Planning Application Ref: R/62/20/HH

Location: Smugglers, 4 Botany Close, Rustington, BN16 2BH

Description of works: Erection of detached garage

Mark Warwick
Tree Officer / Parks and Greenspace Team

183038/ 07

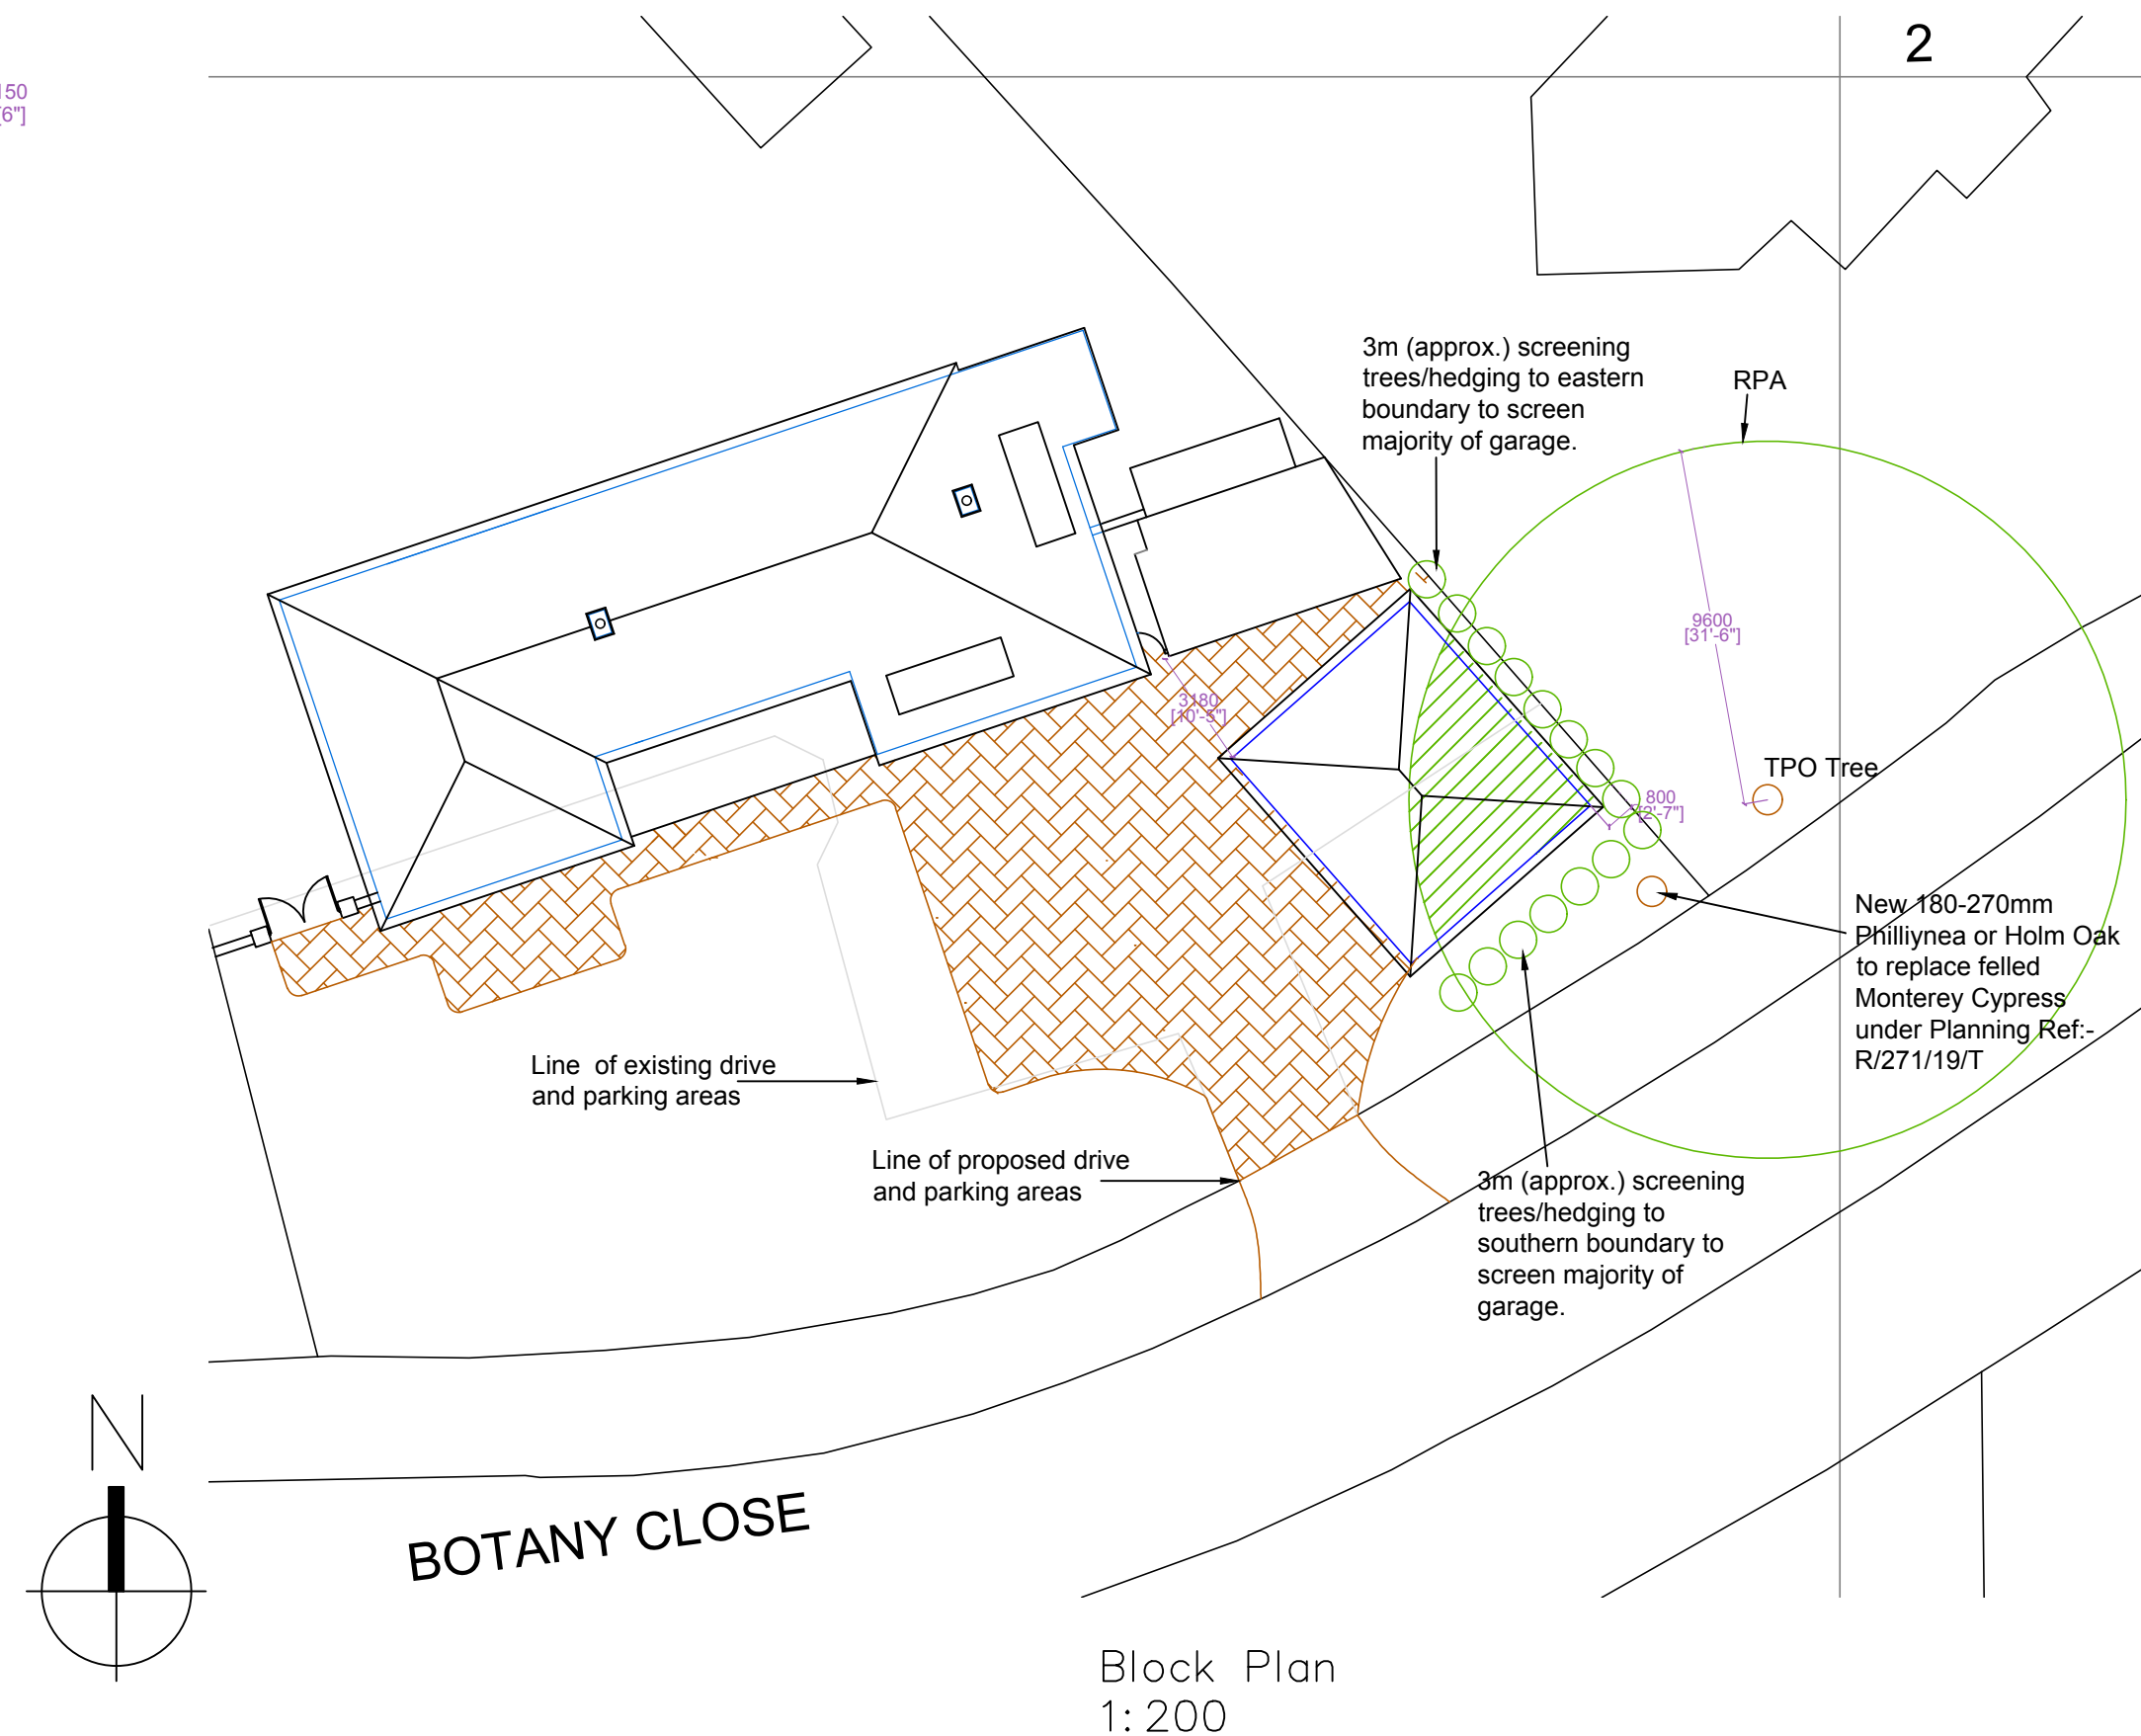
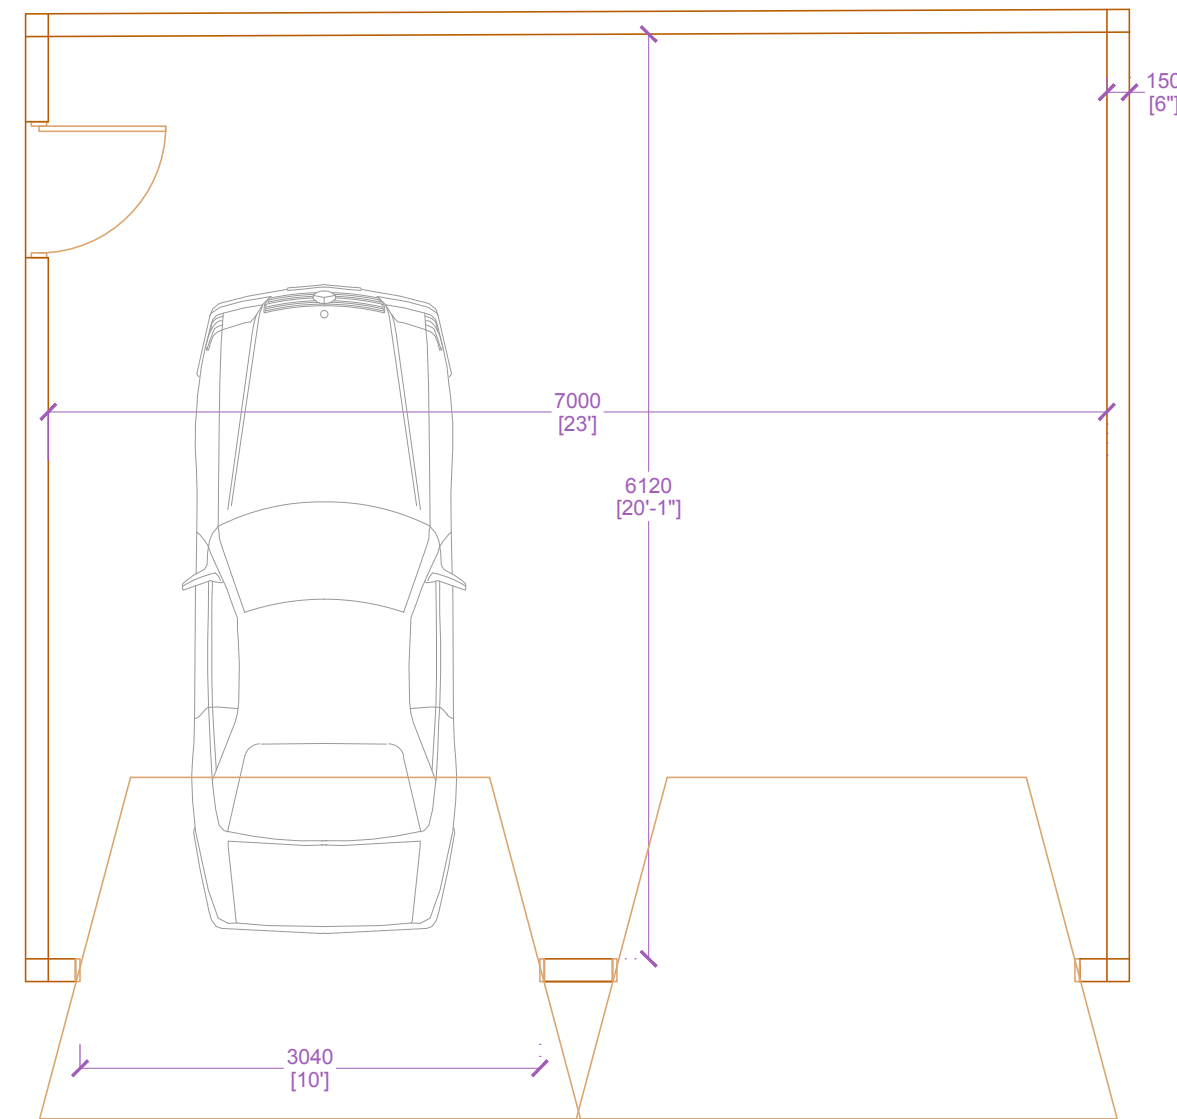
- Membrane to prevent curing concrete coming into direct contact with exposed/cut root material.
- Soft landscape proposals - duty to replant with specimen tree as per R/271/19/T. How will the garage tolerate a tree of such high growth potential in proximity? Should an alternative front garden location be considered for feature tree planting (*Phyllirea latifolia* or *Quercus ilex*)? It has not been demonstrated that the foundation type (concrete slab) will be sufficiently robust to tolerate the high growth potential and ultimate influence over ground conditions at maturity from either replacement tree type.

- The principle of development as described is certainly achievable in arboricultural terms and well-supported by the arboricultural report and plan.
- Given the recent loss of a large tree of high amenity value (the subject of a Tree Preservation Order), it is important that adequate provision is made for a replacement specimen tree to both establish and flourish, and without becoming a subject of harmful pruning work or removal, to secure the structural integrity of built structures. Before approving this application, the applicant should demonstrate that the foundation type will tolerate future growth from such a tree. If this cannot be done, then an alternative foundation should be designed (e.g. pile and beam) or an alternative location for the replacement specimen tree found at the front of the property.
